**FIVE ESTUARIES OFFSHORE WIND FARM DEVELOPMENT CONSENT ORDER**

**PINS REFERENCE EN010115**

**DEADLINE 4: PORT OF LONDON  
AUTHORITY'S COMMENTS ON SUBMISSIONS  
RECEIVED AT DEADLINE 3**

Figure 2.1: Overview of area of interest for NIP.

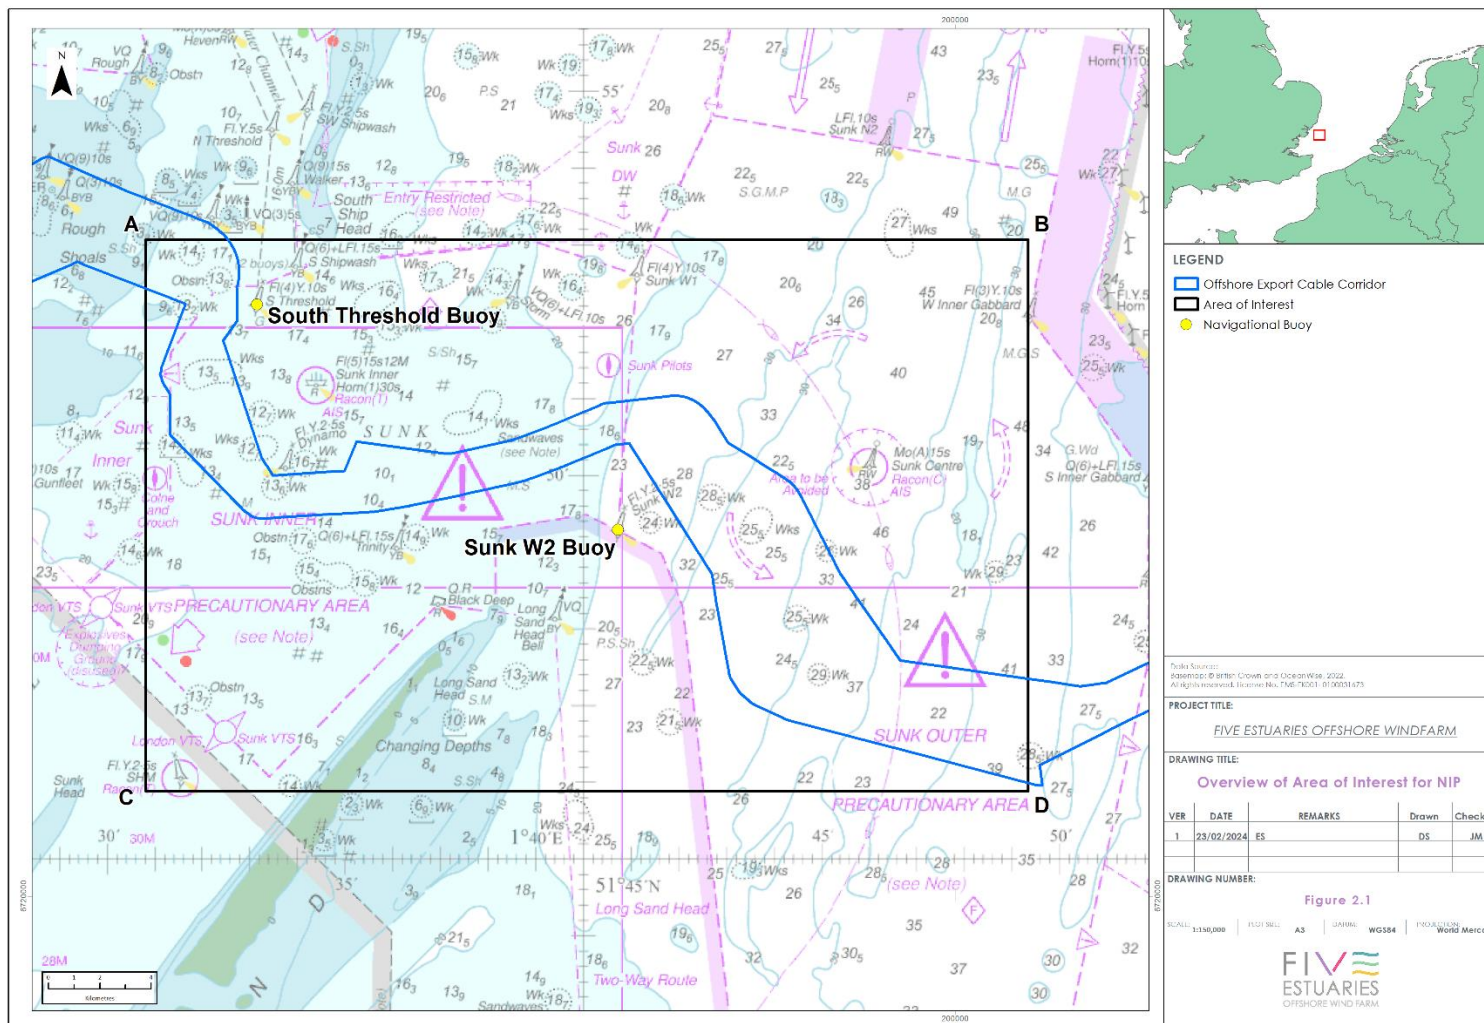
2.1 The PLA welcomes the Applicant’s commitment to “*an under keel clearance of 22m below Chart Datum*”<sup>1</sup>. The PLA and the Applicant continue to discuss, with a view to reaching agreement shortly, the area over which this deeper cable burial needs to be secured.

2.2 Whilst the Applicant has shared with the PLA an updated version of the Navigation Installation Plan (“**NiP**”) since Issue Specific Hearing 3 (“**ISH3**”), the PLA awaits further engagement on the Outline Cable Specification and Installation Plan (“**oCSIP**”)<sup>2</sup>. This further engagement is crucial given the Applicant’s reliance on the CSIP to “*ensure an under keel clearance of 22m below CD is maintained in proximity to the DWRs*”. The lack of engagement is also disappointing given the Applicant’s comments in REP3-024 that “*the oCSIP will be updated and submitted at Deadline 4*”<sup>3</sup>. This means that the oCSIP will have been updated and submitted to the examination without any engagement taking place with the PLA on the contents of the document.

2.3 Whilst the PLA notes the Applicant’s comments in relation to adherence to Marine Guidance Note (“**MGN**”) 654 and its annexes, the Applicant will be relying on the CSIP to identify areas where they can be no reduction in under keel clearance and adherence to MGN654 will apply to the rest of the Order Limits<sup>4</sup>. In the absence of changes to the Deemed Marine Licence (“**DML**”) this could result in confusion and the necessary requirements not being met at the deep water routes (“**DWRs**”). The PLA considers that the following amendments are required to Schedule 11 Part 2 Condition 4 of the draft Development Consent Order (“**dDCO**”) (additional text in bold):

(a) **in any area outside of the Area of Interest** by more than 5% unless agreed with the MMO in writing; **and**

(b) **within the Area of Interest so that the water depth in the Sunk and Trinity deep water would not be maintained at all states of tide to at least 22m below Chart Datum.**
